FIRE RISK MANAGEMENT, INC.

October 31, 2017

CODE COMPLIANCE REVIEW OF THE NEW MIXED-USE BUILDING AT 0 HANCOCK STREET IN PORTLAND, MAINE

A1.01

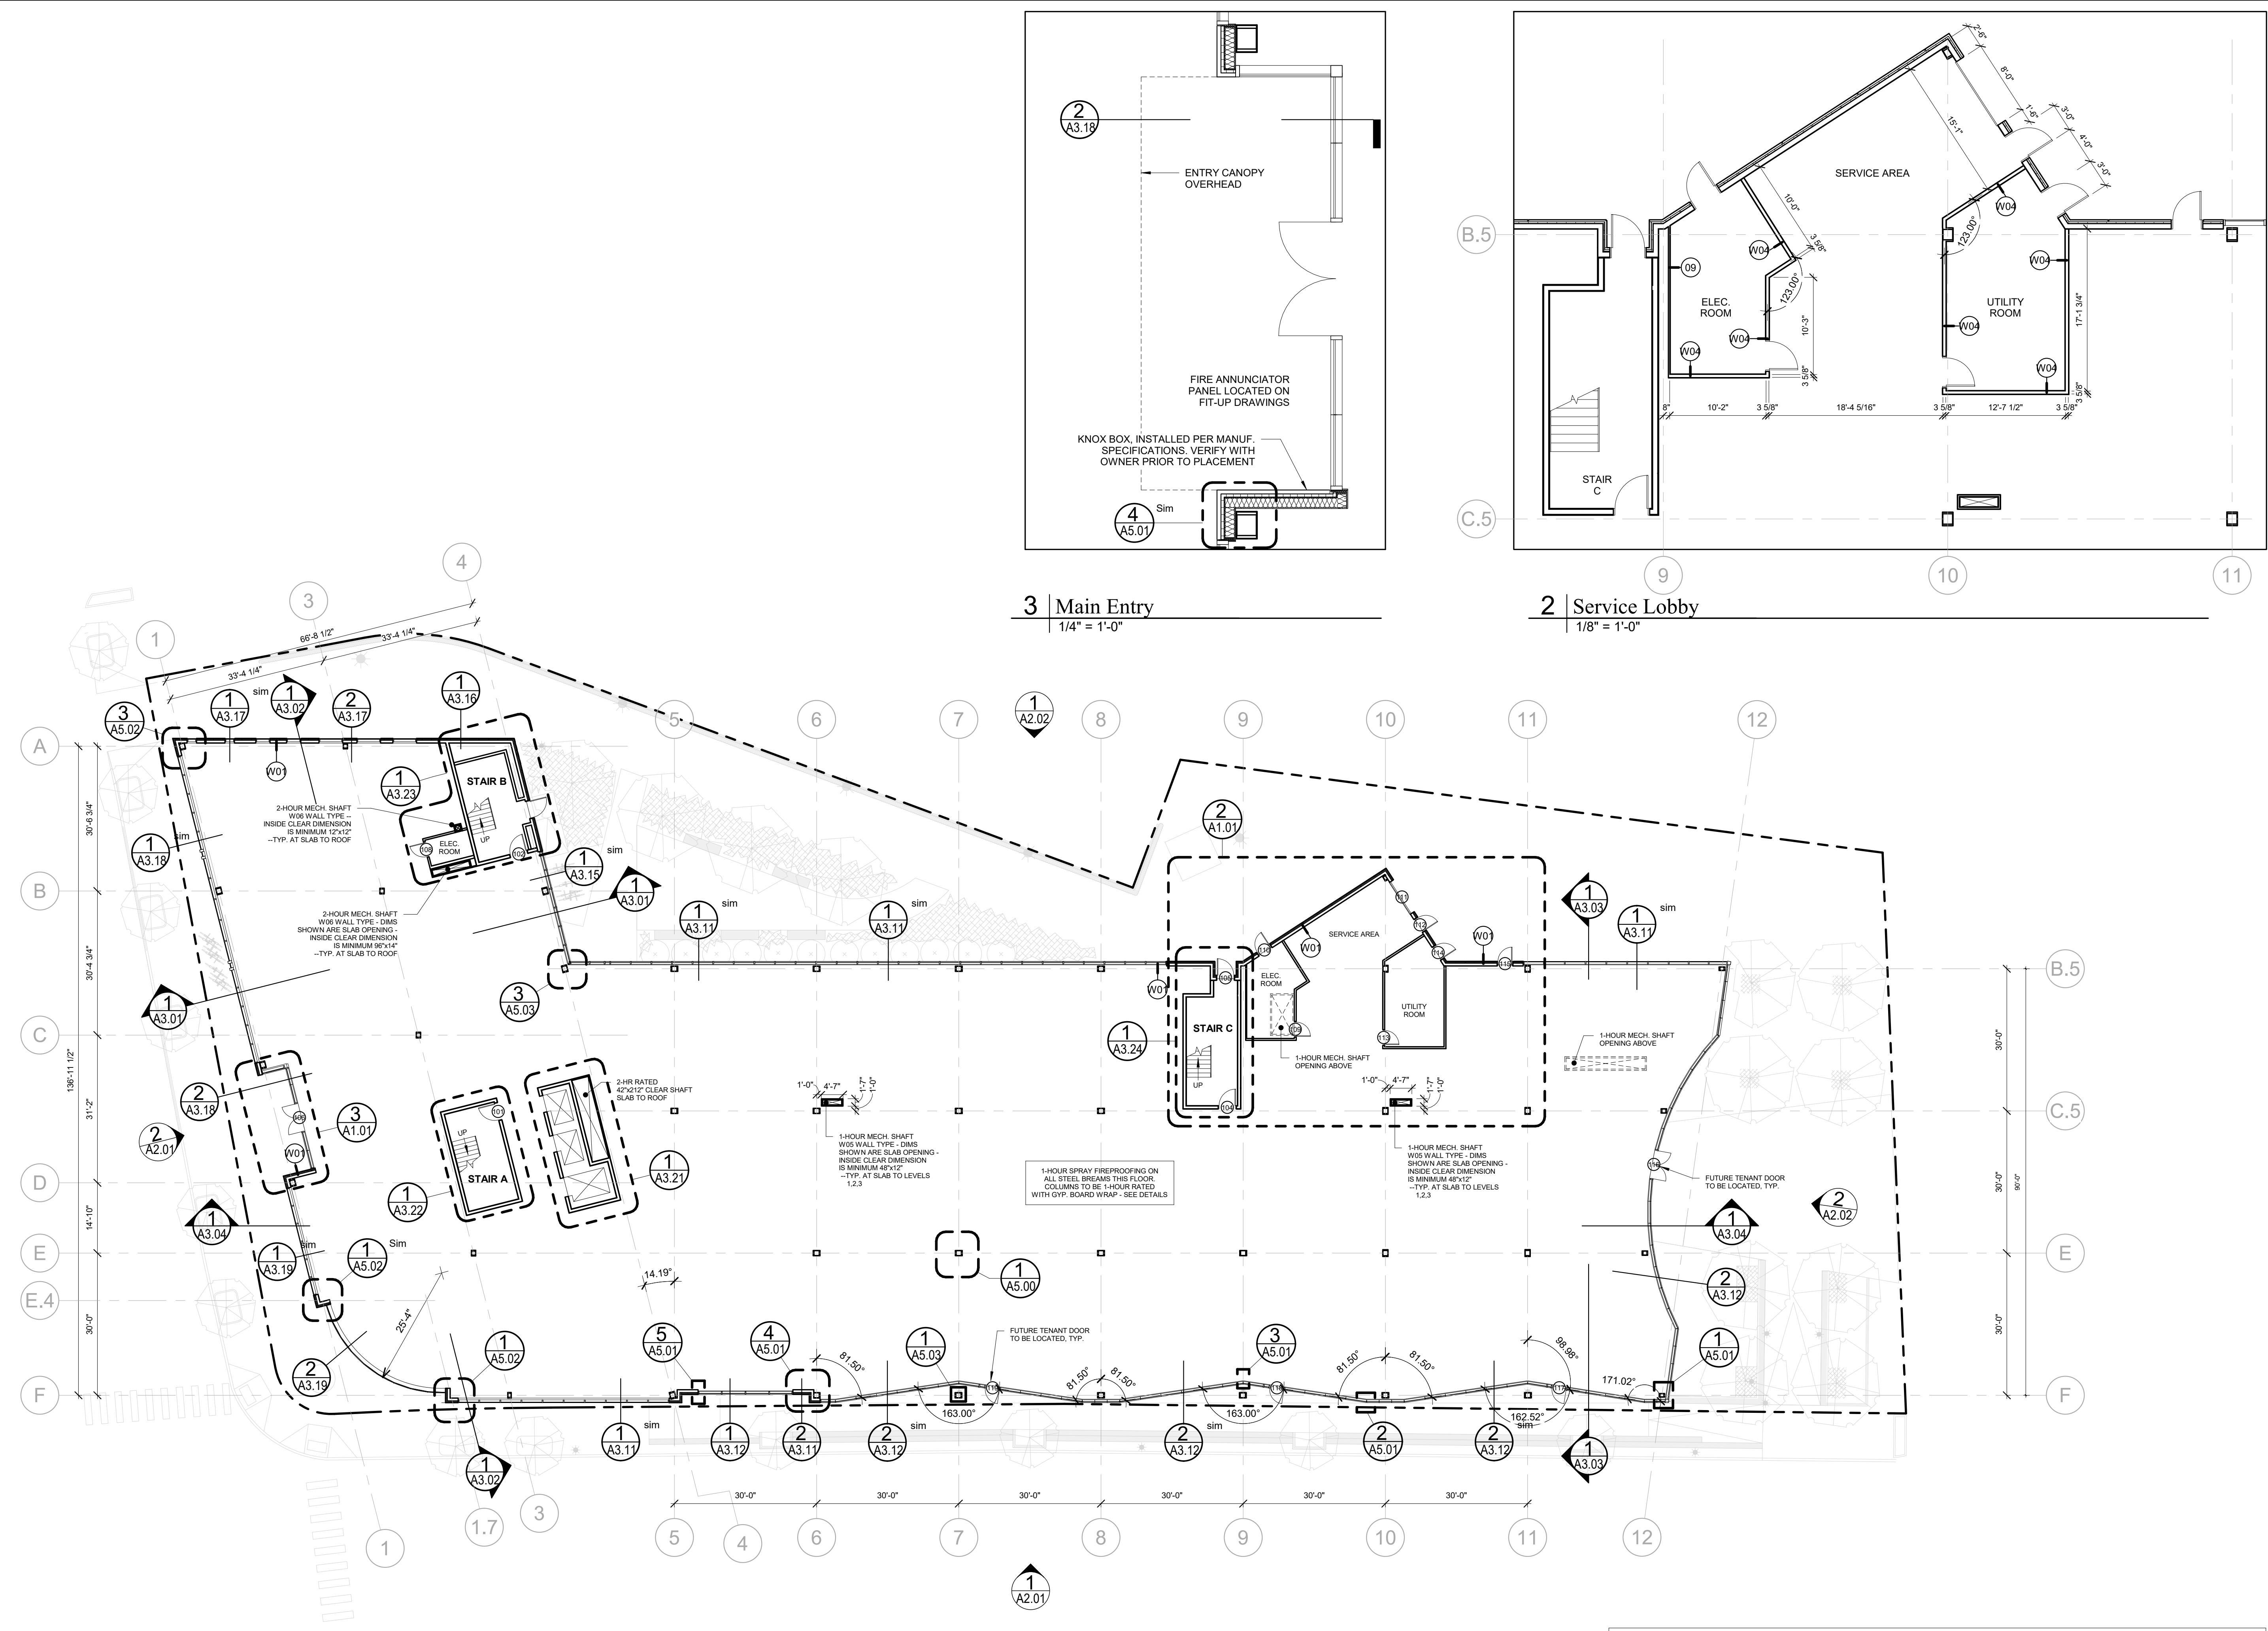
On drawing A1.01, the discharge door from Stair A does not swing in the direction of travel.

LS1.1

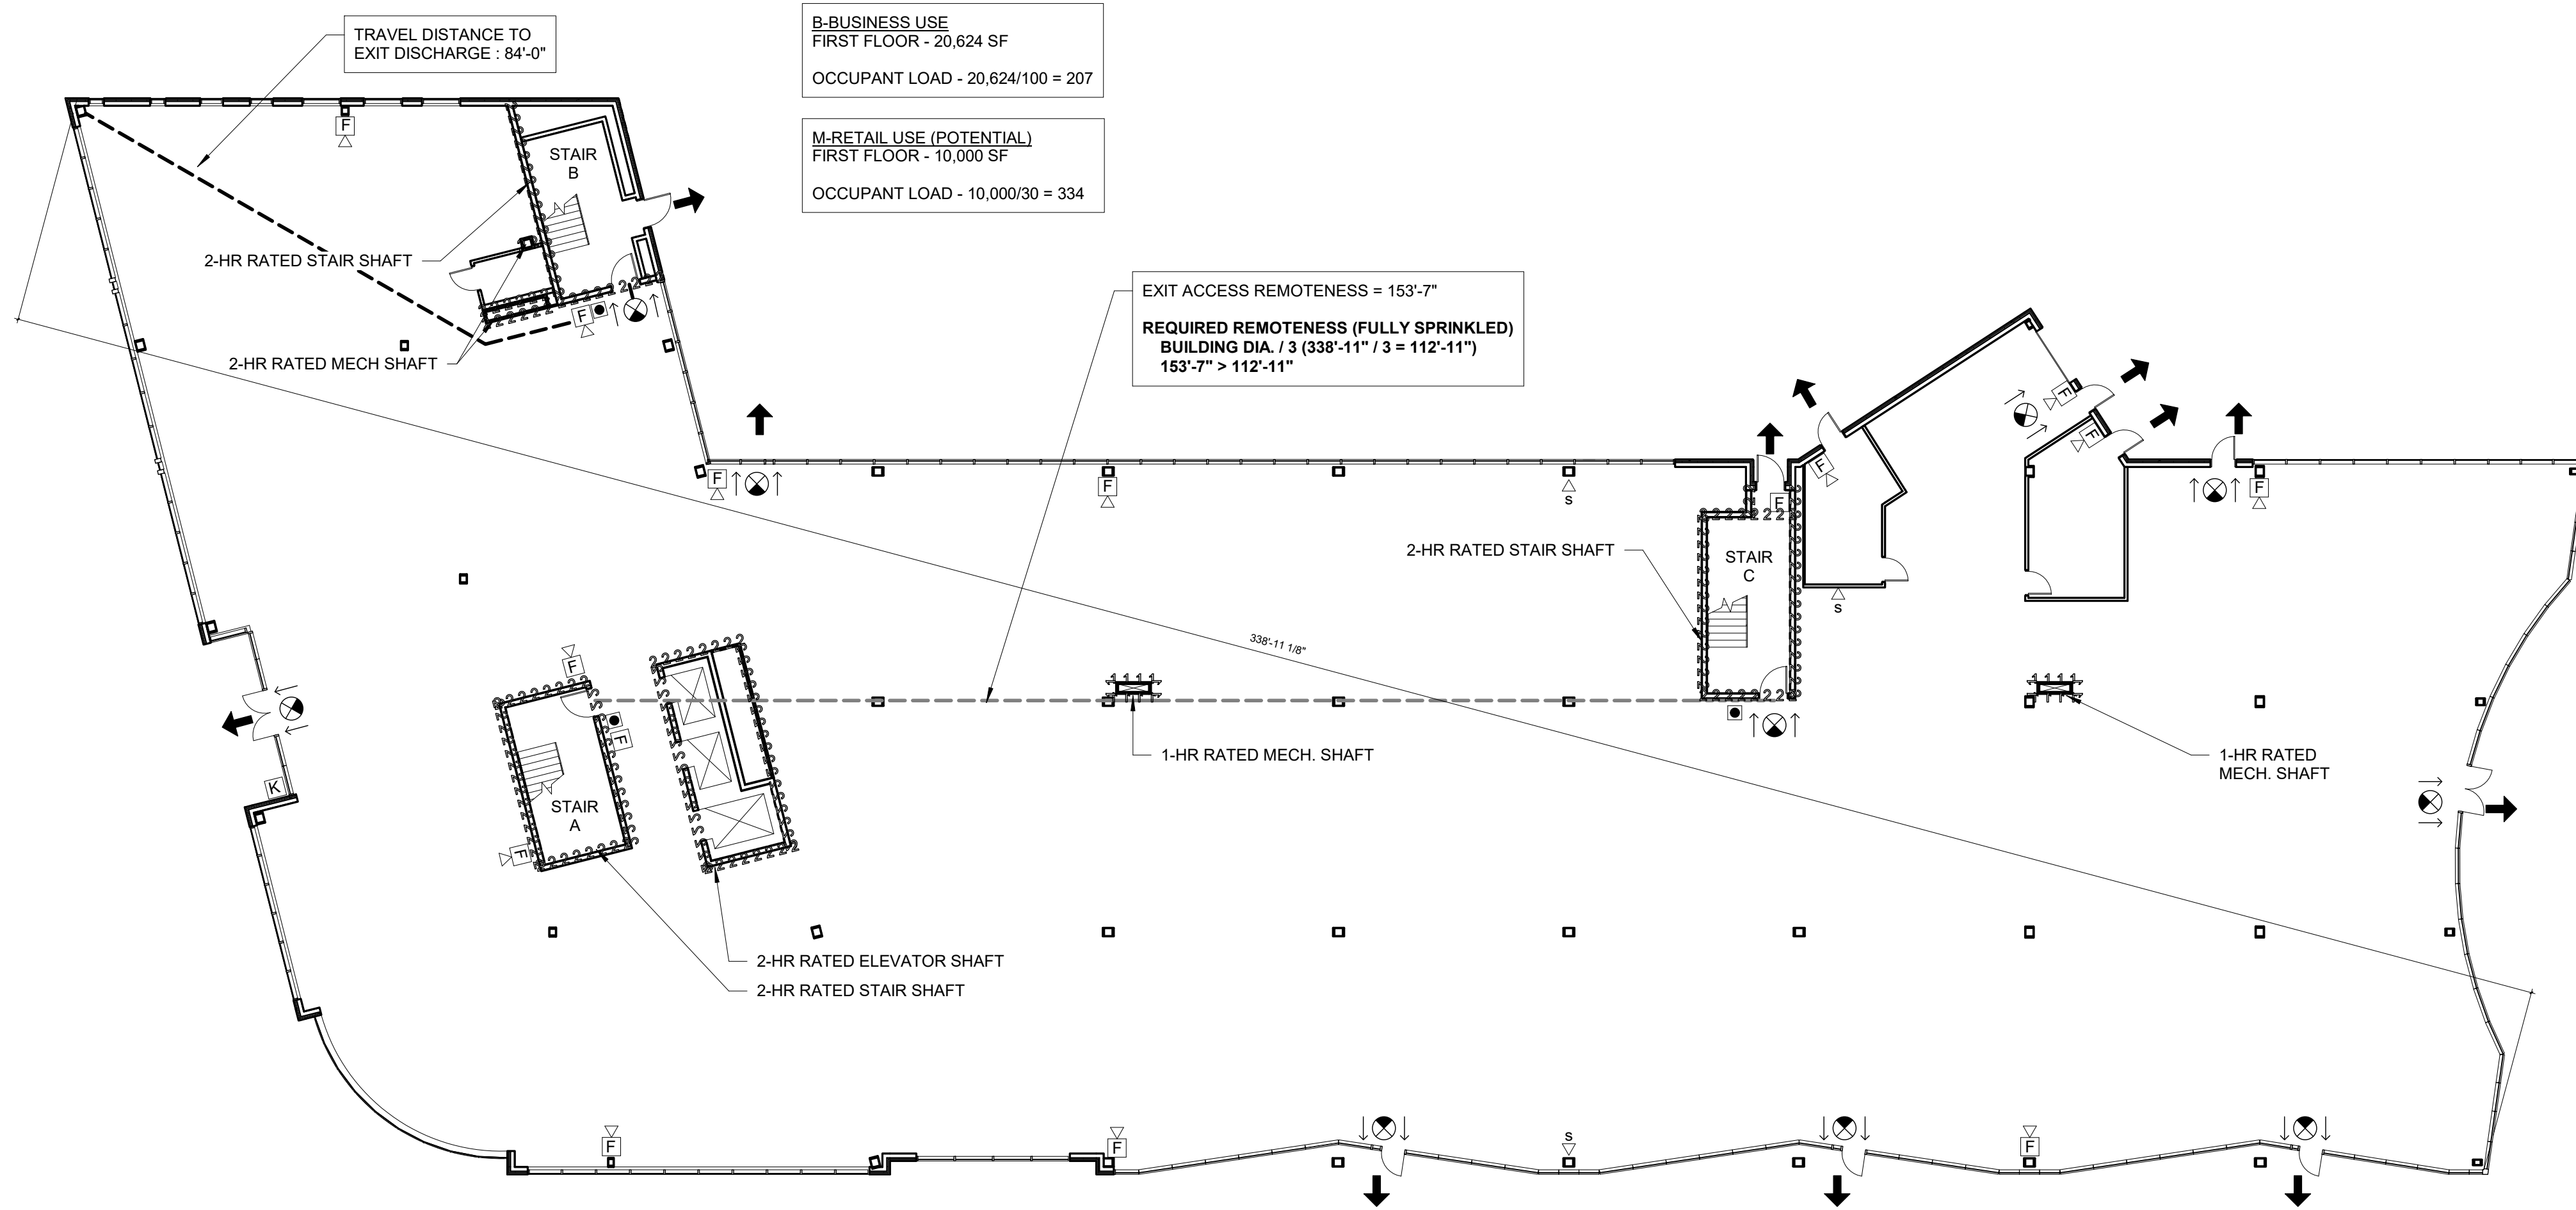
The applicable codes permit a maximum travel distance to the nearest exit to be 300 feet for Business occupancies and 200 feet for Assembly occupancies. These travel distances should be shown on a life safety drawing.
